SSD 8980 Bowral & District Hospital Redevelopment - Response to Submissions Table (Agency)

Issues Raised by Agencies and Organisations		Proponent's Response																																																																																																								
1	Department of Planning & Environment

Main Entry and Carpark

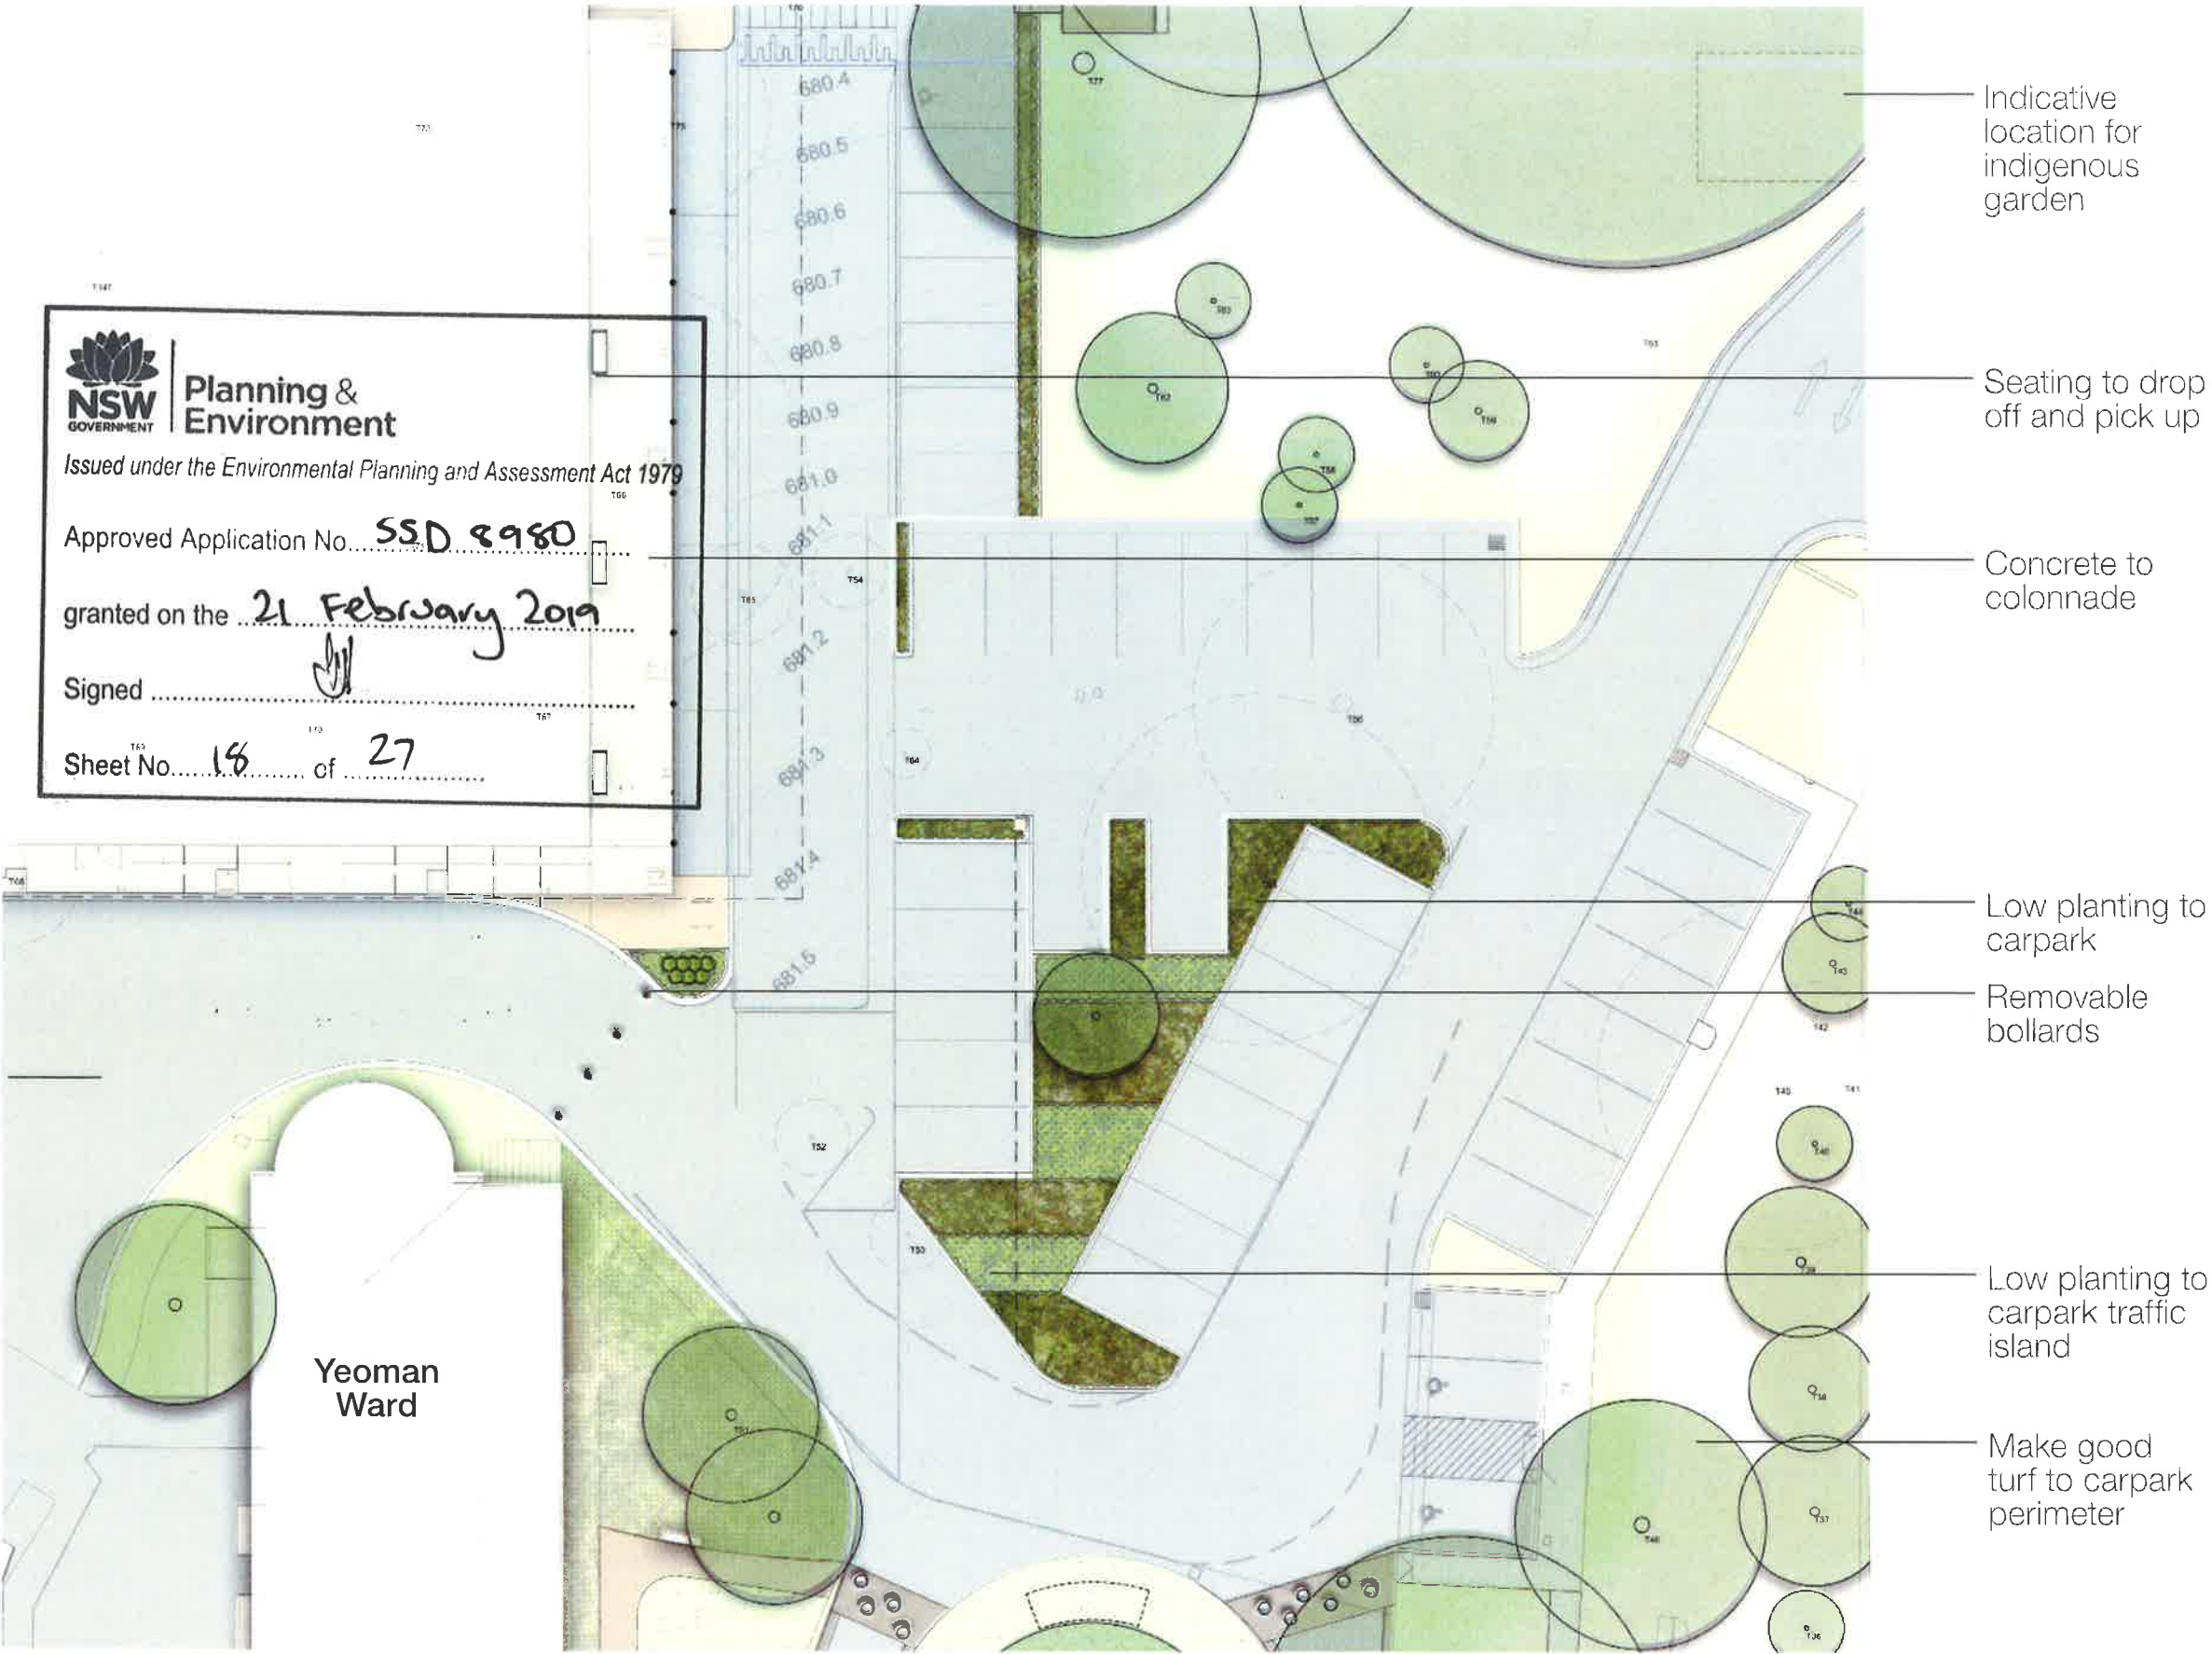
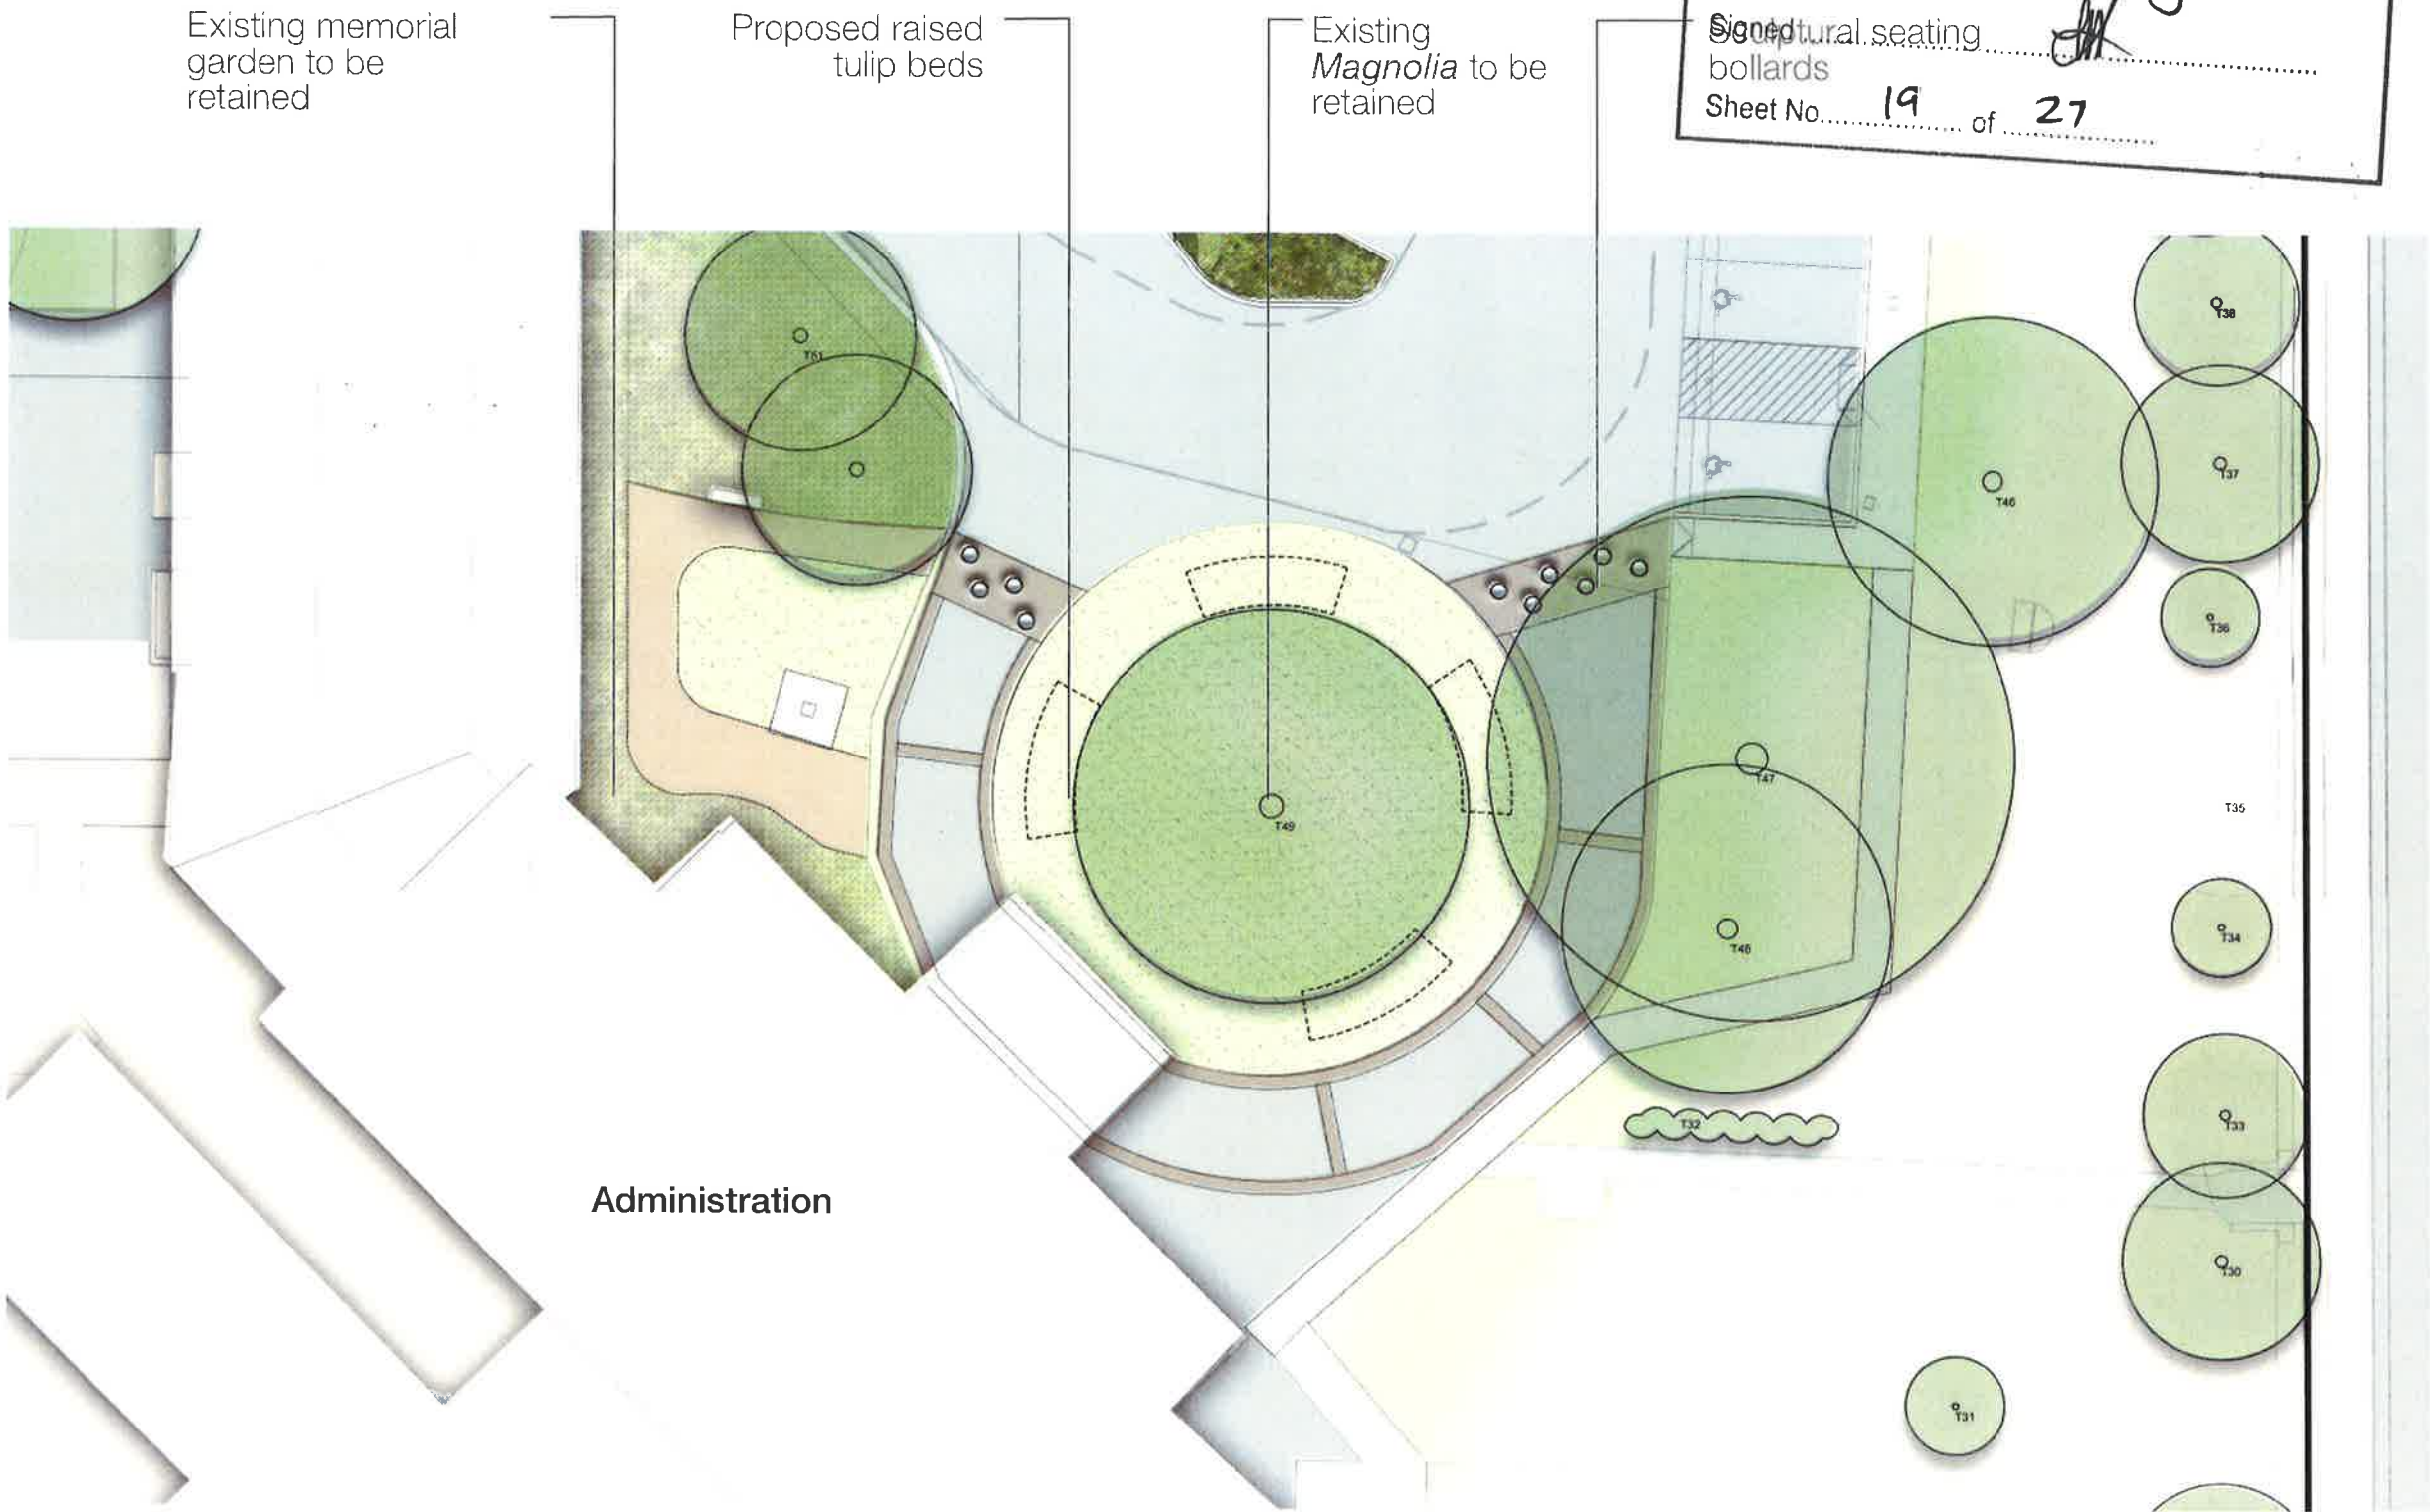
1.3	<ul style="list-style-type: none">the 'main entry and carpark' landscape plan (drawing no.005, issue C) includes several trees along Mona Road frontage identified as tree no/s T40-T45, however there is no mention of these trees in the submitted arborist report.	<ul style="list-style-type: none">The landscape plan has been revised to reflect a number of trees which were removed following an arborist report necessitated their removal.Trees 40-45 were identified for removal due to defects.However in order to retain as many tree as possible, Trees 40, 43, and 44 have been identified as to be retained, subject to appropriate tree protection measures. Additional aboricultural details can be found below; <table><tr><td>40</td><td><i>Prunus serrulata</i></td><td>3</td><td>3</td><td>100</td><td>2.0</td><td>70%</td><td>M</td><td>Borer, Lopped branches</td><td>Garden bed</td><td>Nil</td><td>L</td><td>ZZ4</td></tr><tr><td>41</td><td><i>Japonica cryptomeria</i></td><td>8</td><td>3</td><td>350</td><td>4.2</td><td>70%</td><td>M</td><td>Poor form</td><td>Garden bed</td><td>Nil</td><td>M</td><td>Z10</td></tr><tr><td>42</td><td><i>Prunus serrulata</i></td><td>3</td><td>3</td><td>100</td><td>2.0</td><td>70%</td><td>M</td><td>Borer, Lopped branches</td><td>Garden bed</td><td>Nil</td><td>L</td><td>ZZ4</td></tr><tr><td>43</td><td><i>Japonica cryptomeria</i></td><td>9</td><td>4</td><td>350</td><td>4.2</td><td>80%</td><td>M</td><td>Multi-trunked</td><td>Garden bed</td><td>Nil</td><td>M</td><td>Z9</td></tr></table> <div><div>Report on trees at Bowral & District Hospital, Bowral Street, Bowral for Health Infrastructure NSW Ref: Bowral Hospital_AIA and MS_REF Enabling Works.doc – 09/11/17 Naturally Trees Arboricultural Consulting © www.naturallytrees.com.au</div><div></div></div> <table><tr><th>No.</th><th>Genus species</th><th>Height</th><th>Spread</th><th>DBH</th><th>TPZ</th><th>Foliage %</th><th>Age class</th><th>Defects/Comment</th><th>Location</th><th>Services</th><th>Significance</th><th>Tree AZ</th></tr><tr><td>44</td><td><i>Prunus serrulata</i></td><td>3</td><td>3</td><td>100</td><td>2.0</td><td>70%</td><td>M</td><td>Borer, Lopped branches</td><td>Garden bed</td><td>Nil</td><td>L</td><td>ZZ4</td></tr><tr><td>45</td><td><i>Liquidambar styraciflua</i></td><td>14</td><td>14</td><td>600</td><td>7.2</td><td>60%</td><td>O</td><td>Basal cavity</td><td>Grass</td><td>Adjacent structure</td><td>H</td><td>ZZ5</td></tr><tr><td>46</td><td><i>Picea sp</i></td><td>22</td><td>10</td><td>600</td><td>7.2</td><td>80%</td><td>M</td><td>Nil</td><td>Grass</td><td>Nil</td><td>H</td><td>AA1</td></tr></table>	40	<i>Prunus serrulata</i>	3	3	100	2.0	70%	M	Borer, Lopped branches	Garden bed	Nil	L	ZZ4	41	<i>Japonica cryptomeria</i>	8	3	350	4.2	70%	M	Poor form	Garden bed	Nil	M	Z10	42	<i>Prunus serrulata</i>	3	3	100	2.0	70%	M	Borer, Lopped branches	Garden bed	Nil	L	ZZ4	43	<i>Japonica cryptomeria</i>	9	4	350	4.2	80%	M	Multi-trunked	Garden bed	Nil	M	Z9	No.	Genus species	Height	Spread	DBH	TPZ	Foliage %	Age class	Defects/Comment	Location	Services	Significance	Tree AZ	44	<i>Prunus serrulata</i>	3	3	100	2.0	70%	M	Borer, Lopped branches	Garden bed	Nil	L	ZZ4	45	<i>Liquidambar styraciflua</i>	14	14	600	7.2	60%	O	Basal cavity	Grass	Adjacent structure	H	ZZ5	46	<i>Picea sp</i>	22	10	600	7.2	80%	M	Nil	Grass	Nil	H	AA1
